SADDLEHORN RANCH FILING NO.4

A PARCEL OF LAND LOCATED IN SECTION 3 TOWNSHIP 13 SOUTH, RANGE 64 WEST OF THE 6TH PRINCIPAL MERIDIAN COUNTY OF EL PASO, STATE OF COLORADO

JOB NO. 25142.06
OCTOBER 4, 2023
SHEET 1 OF 4

PCD FILE: SF-23-006

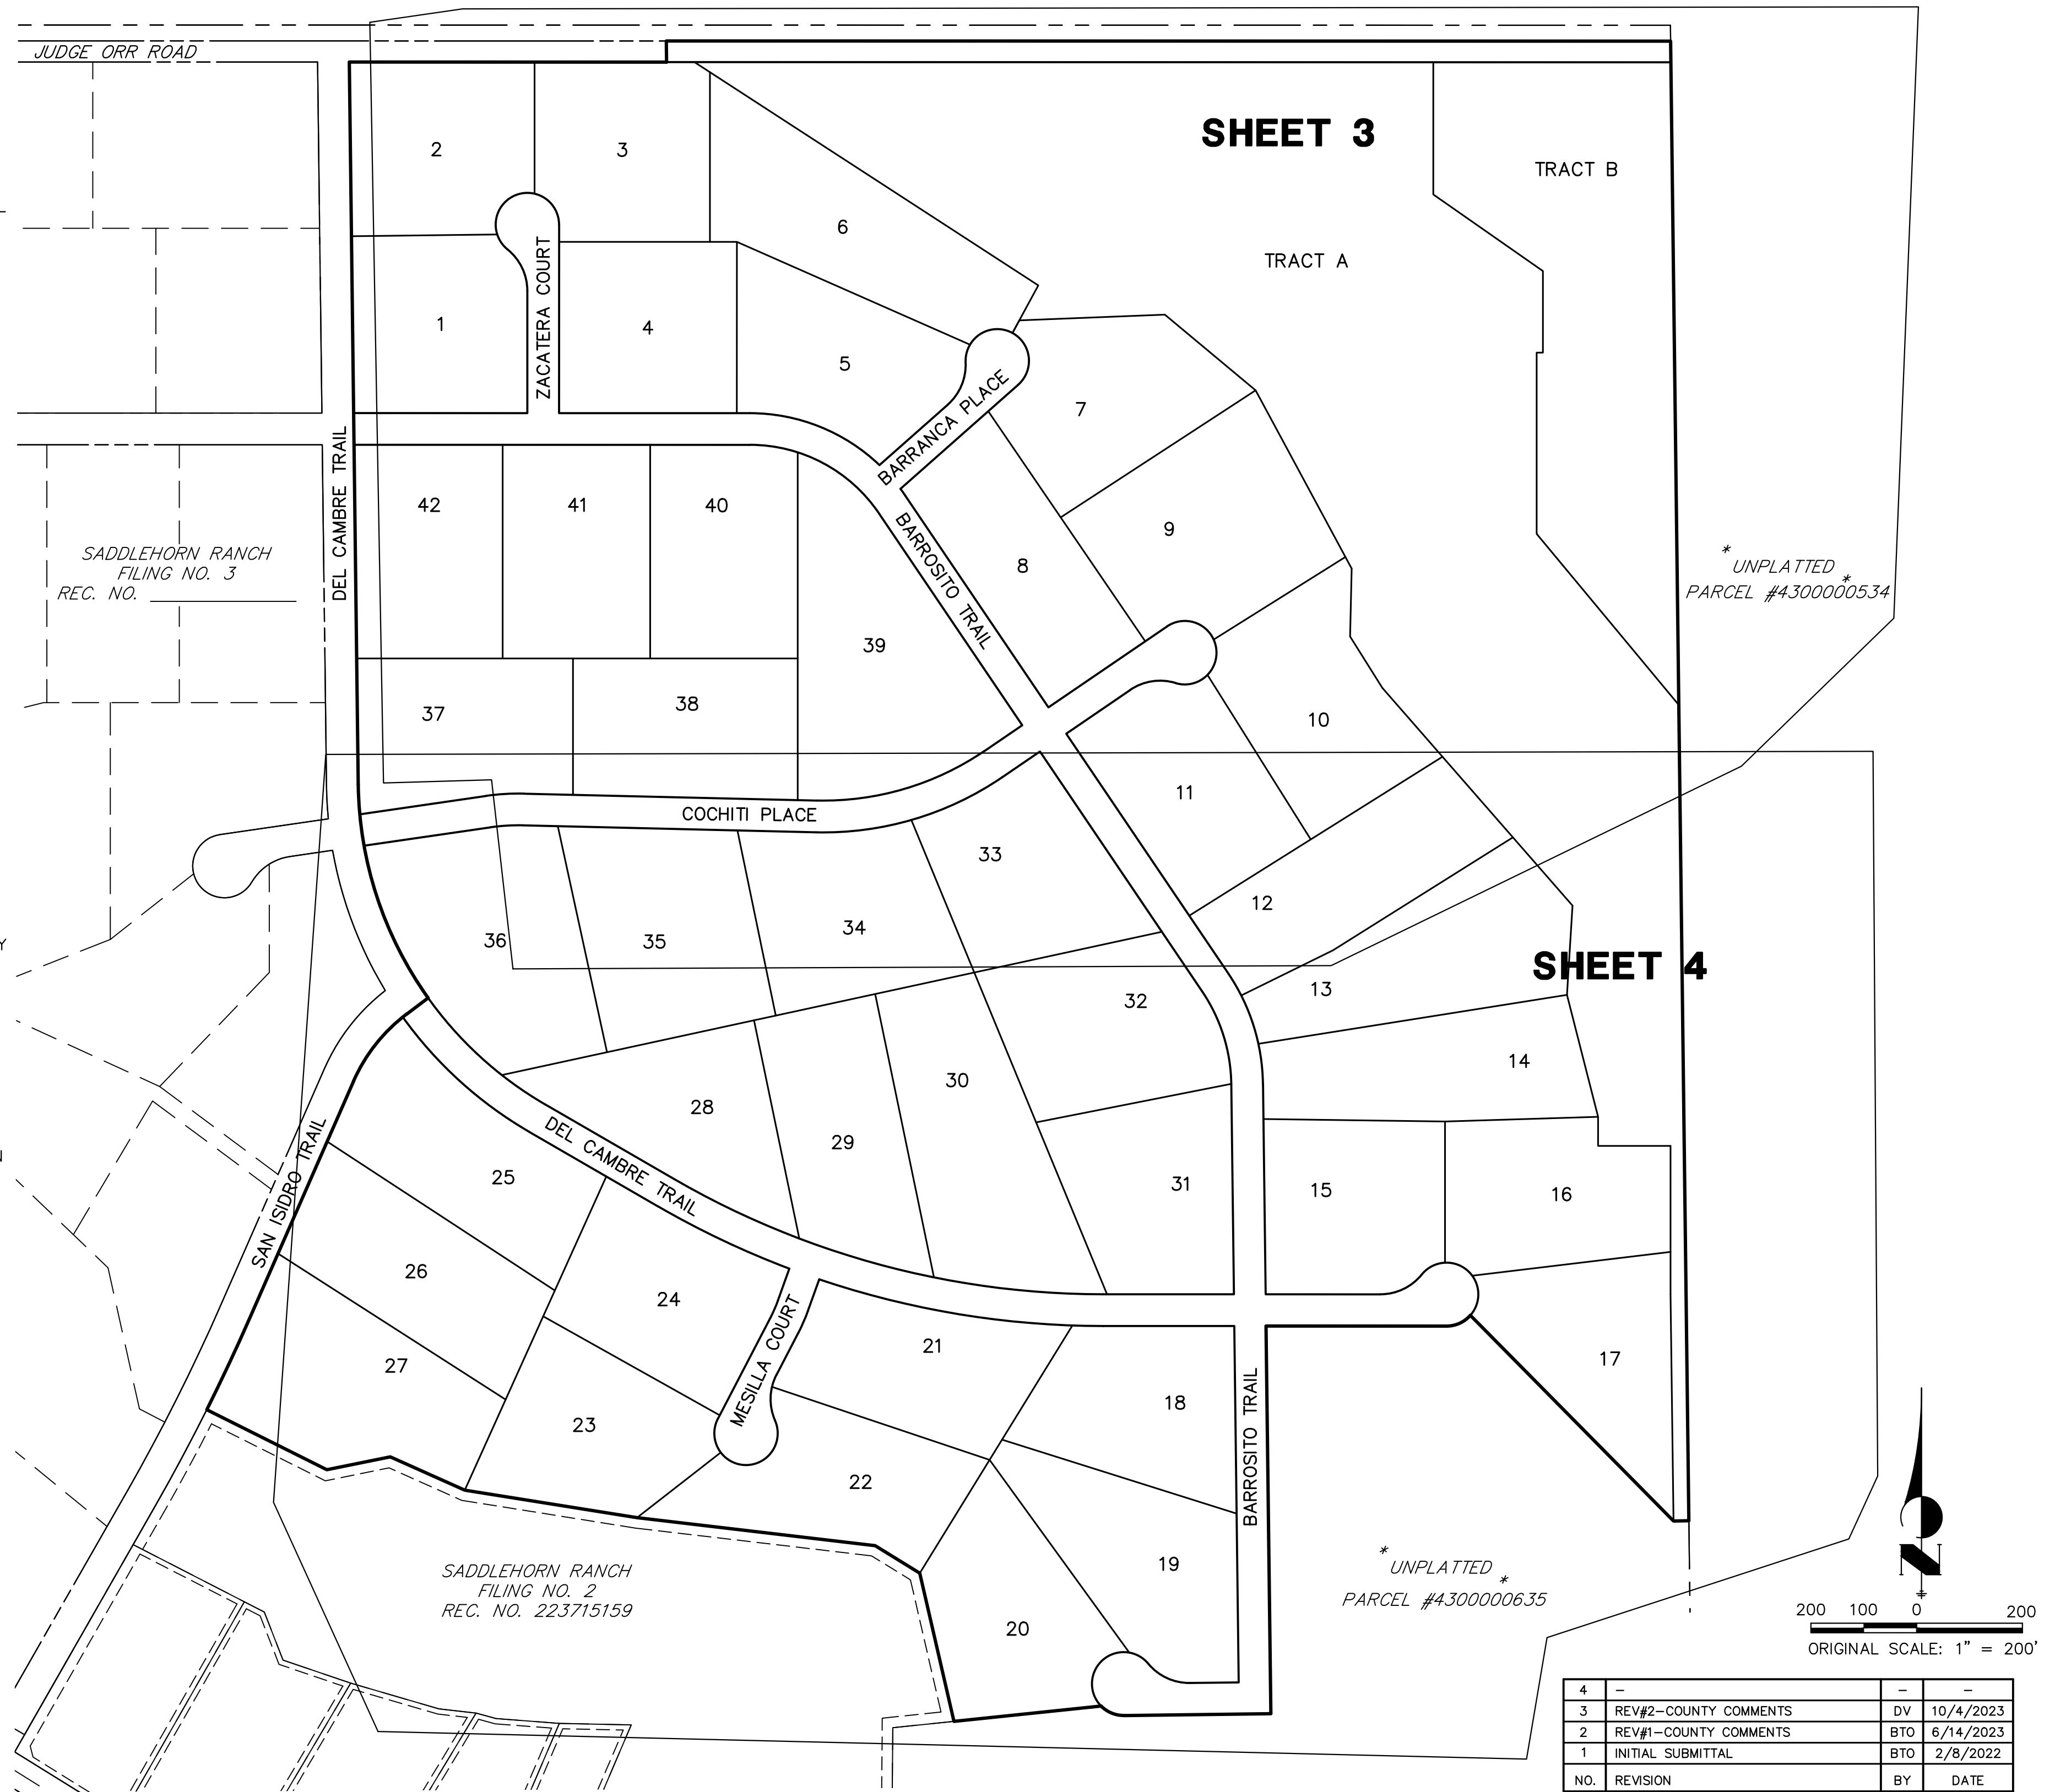
Add a note stating that impervious lot coverage is limited to 10% (based on MS4 exclusion)

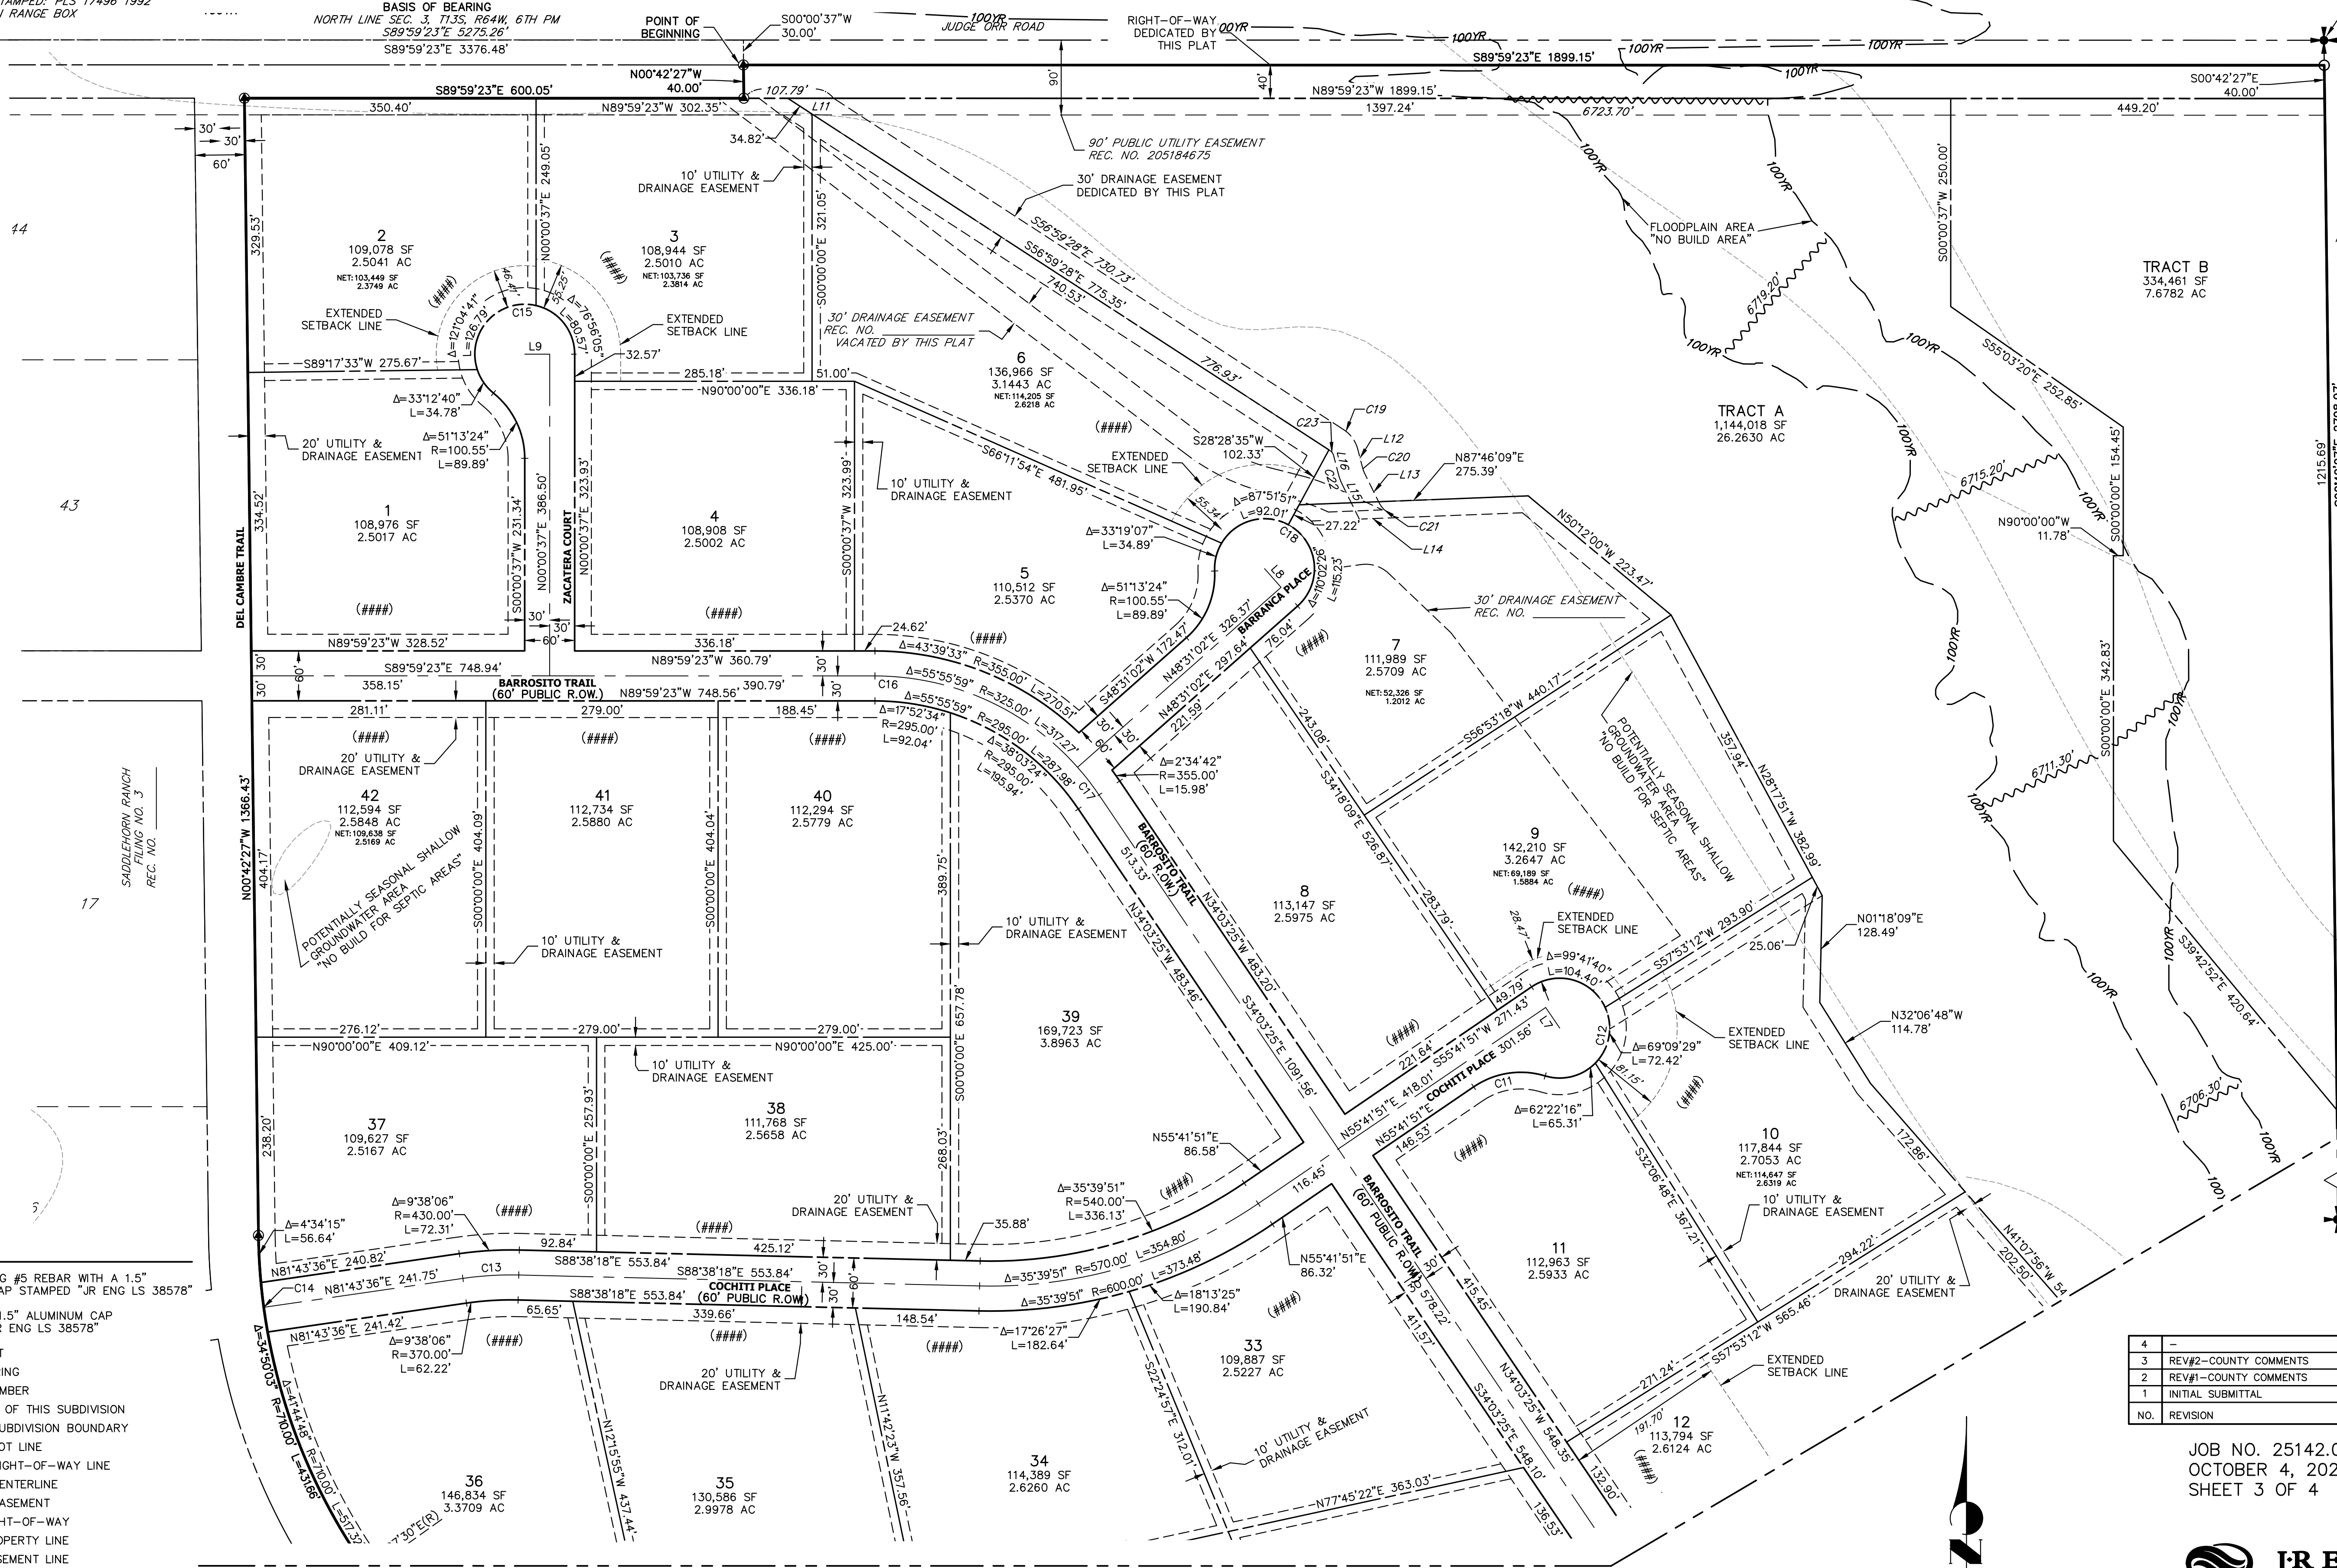
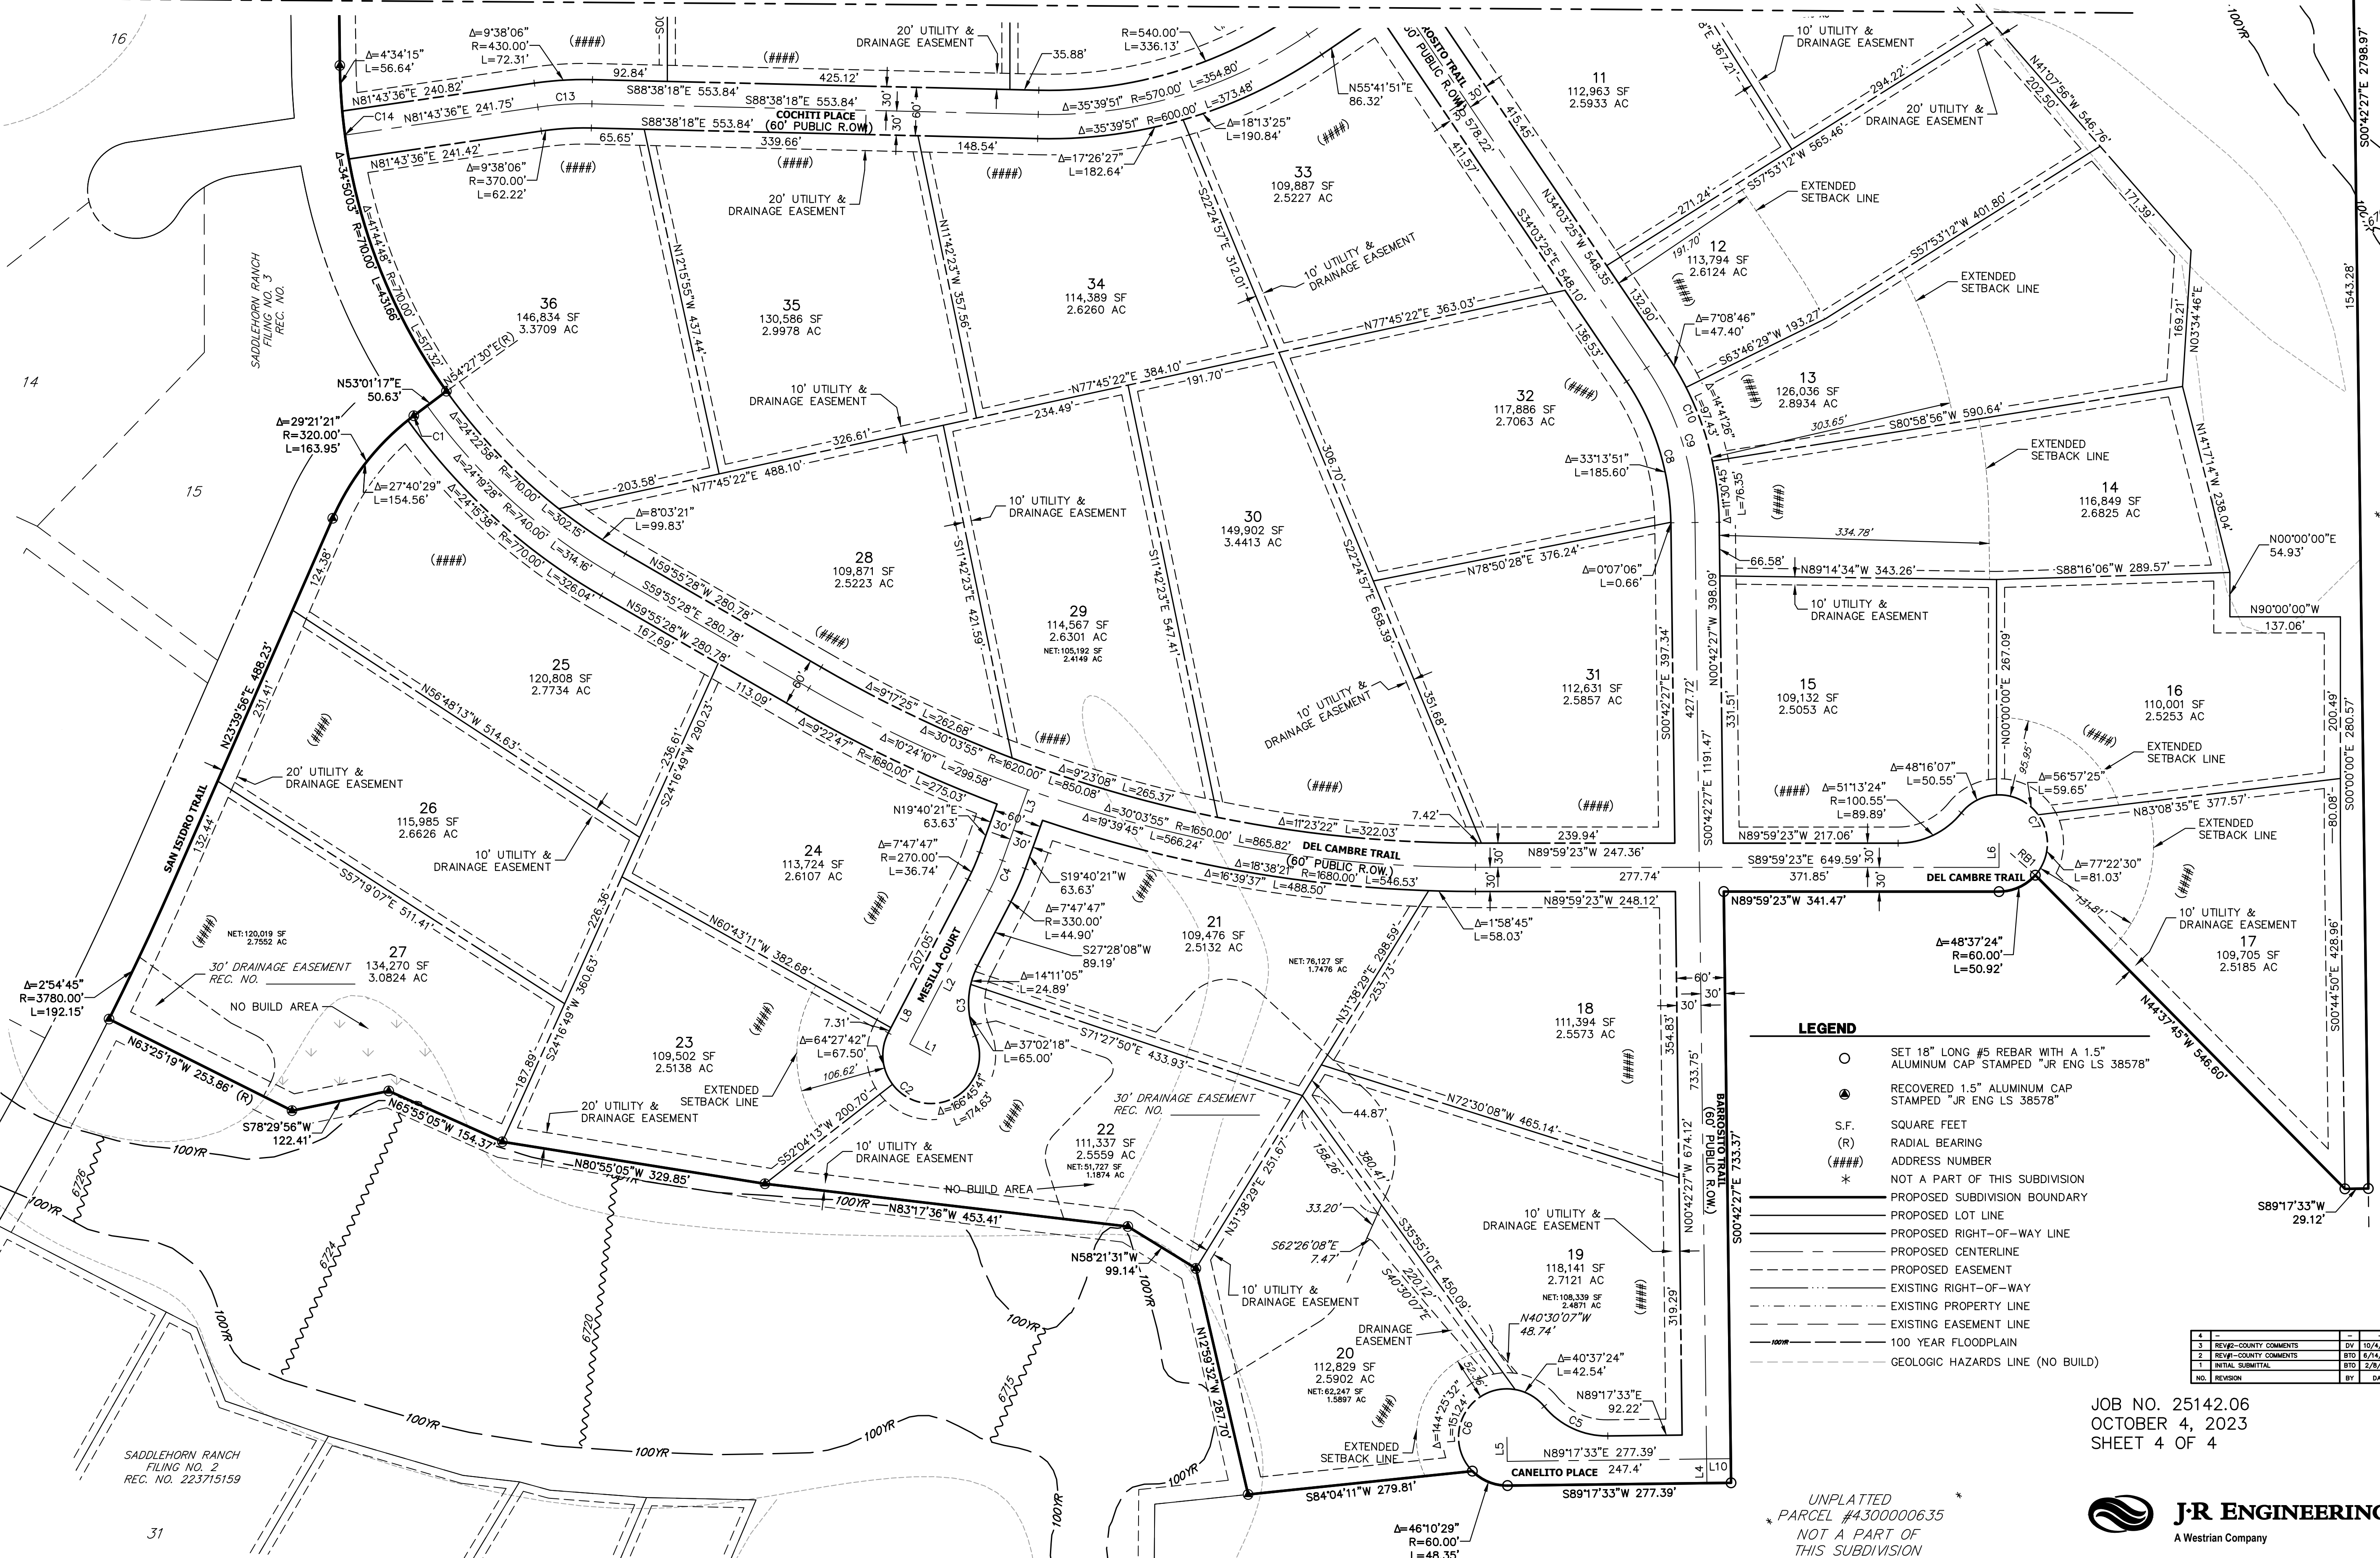
Correct effective floodplain per
RBD Floodplain notes
